CITY OF ALBUQUERQUE

September 20, 2012

**Re: AMERICA'S PASSTIME, Grading and Drainage Plan
Engineer's Stamp Date 08/28/2012 (C18/D035)**

AMERICA'S PASTTIME
GRADING & DRAINAGE PLAN

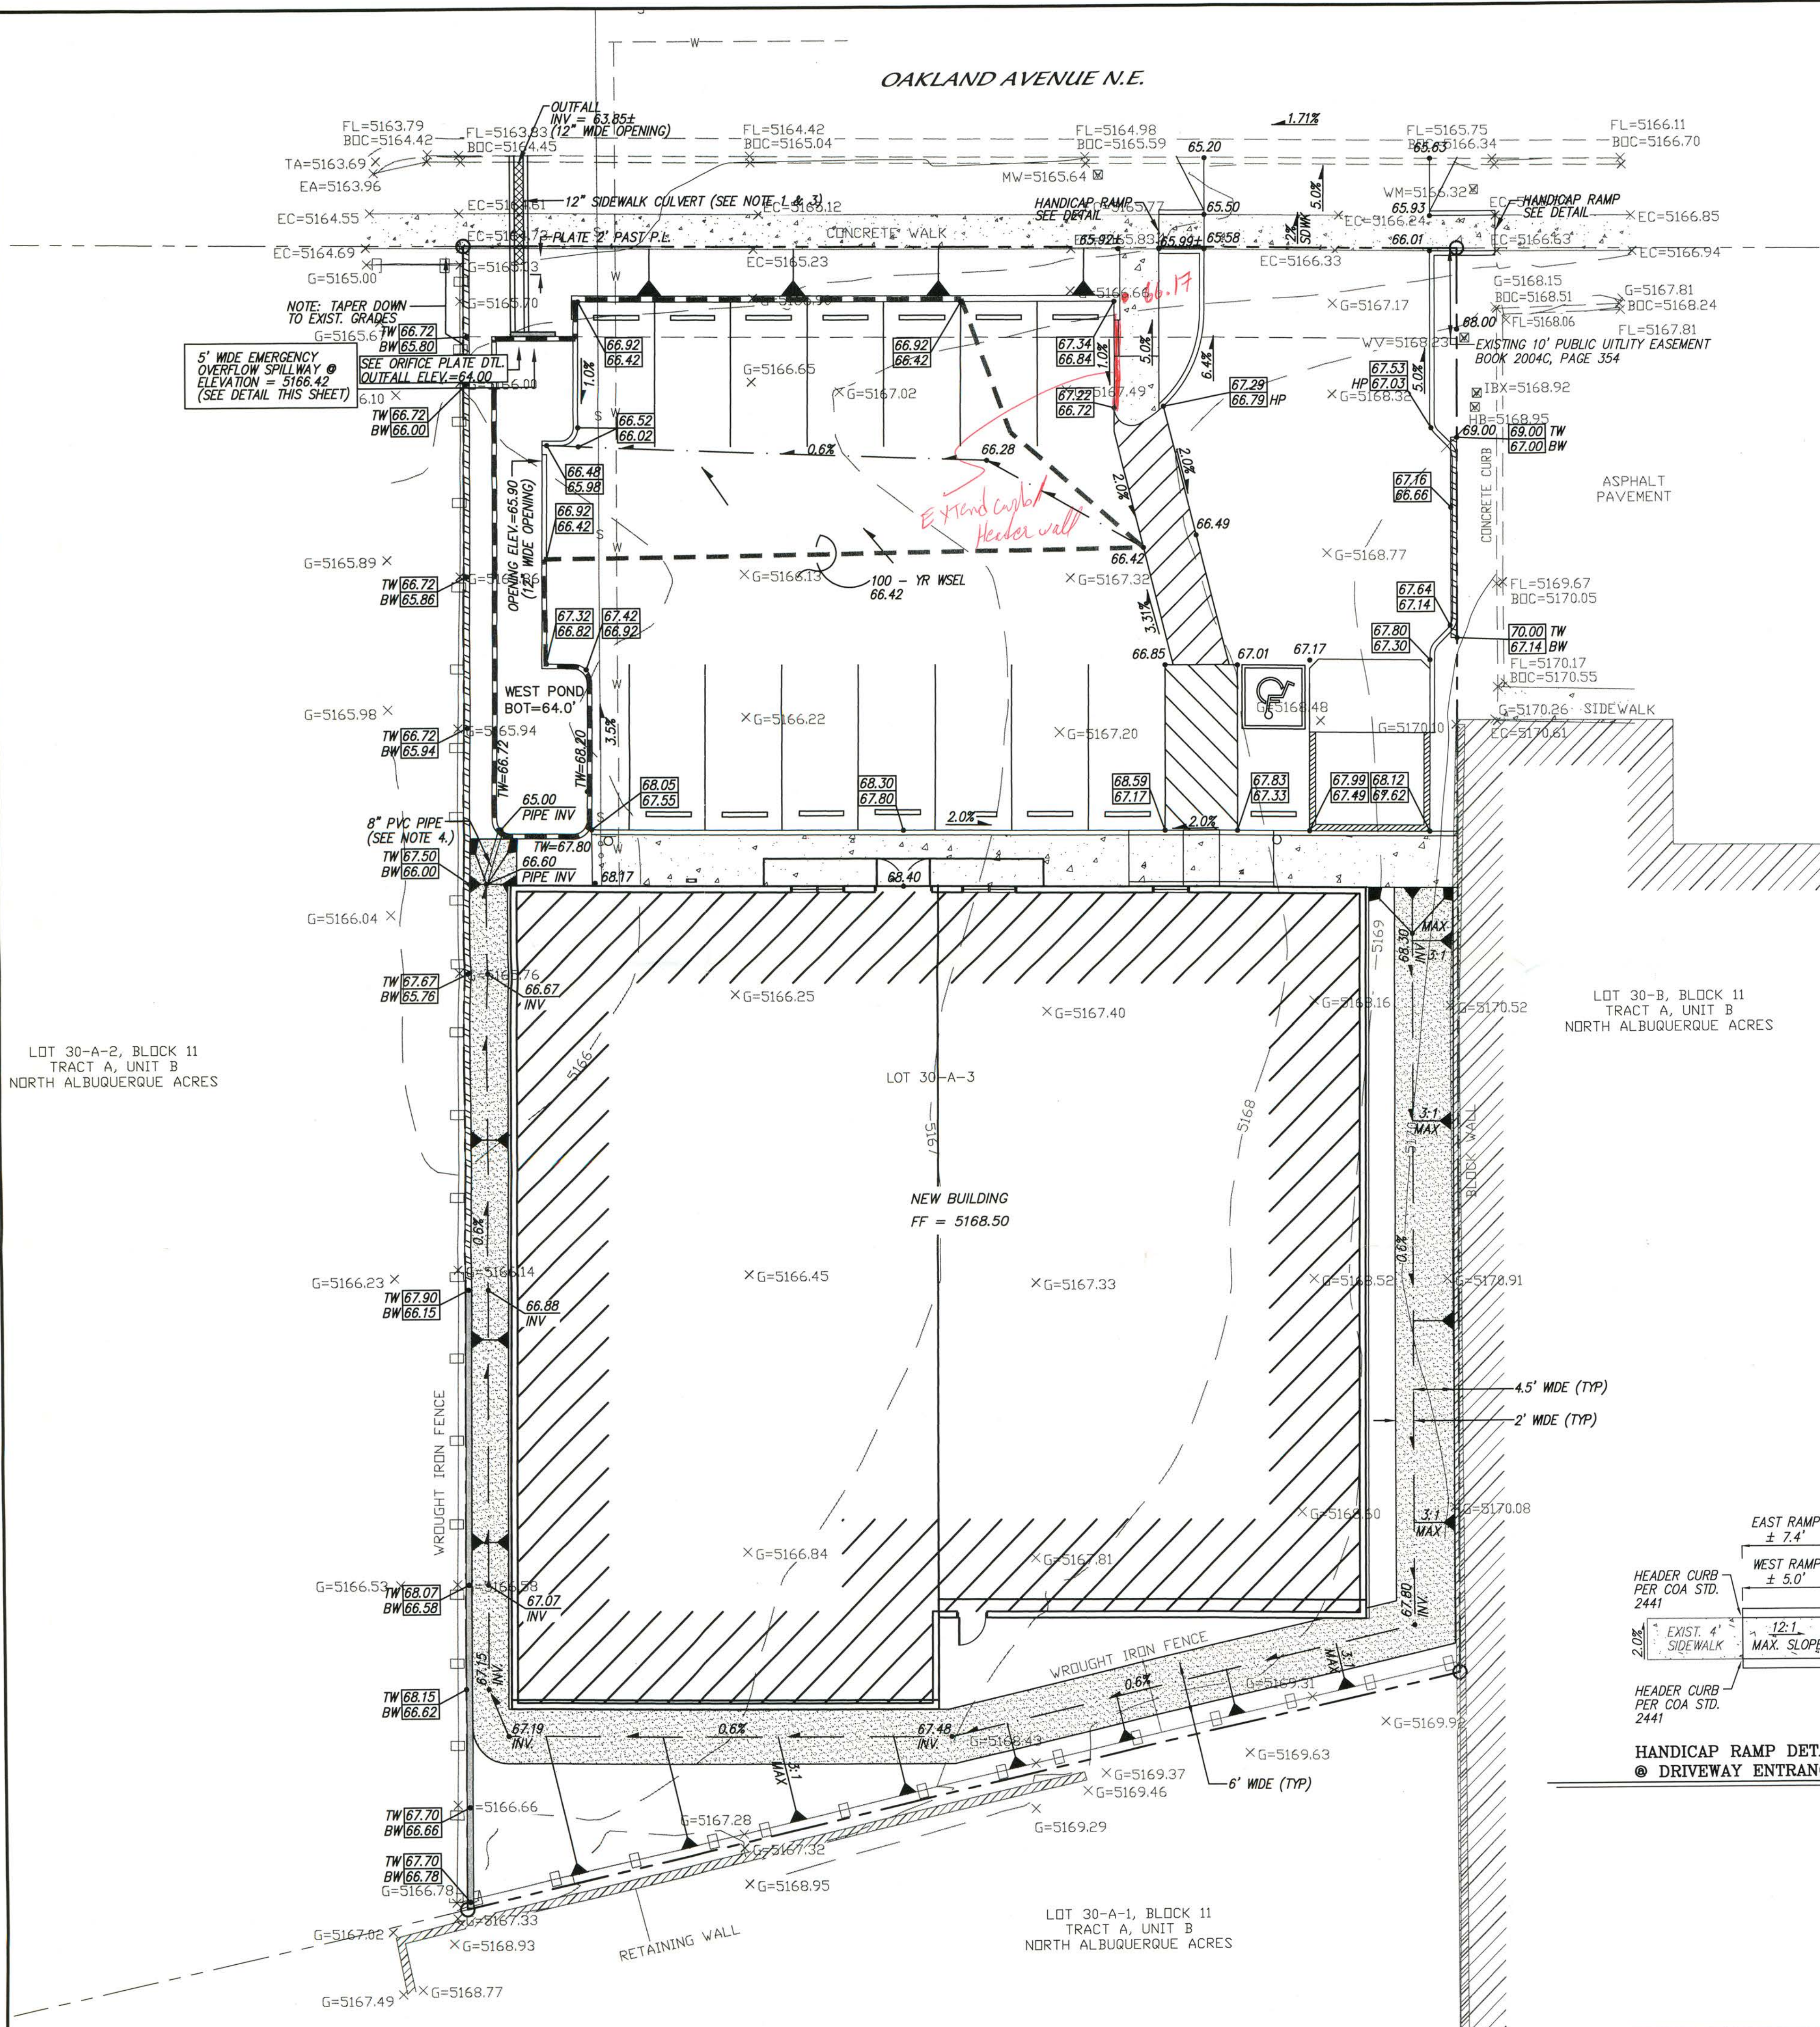
- We will require a confirmation from the Architect that the pedestrian connection from the building to the public sidewalk does not have to meet ADA requirements.
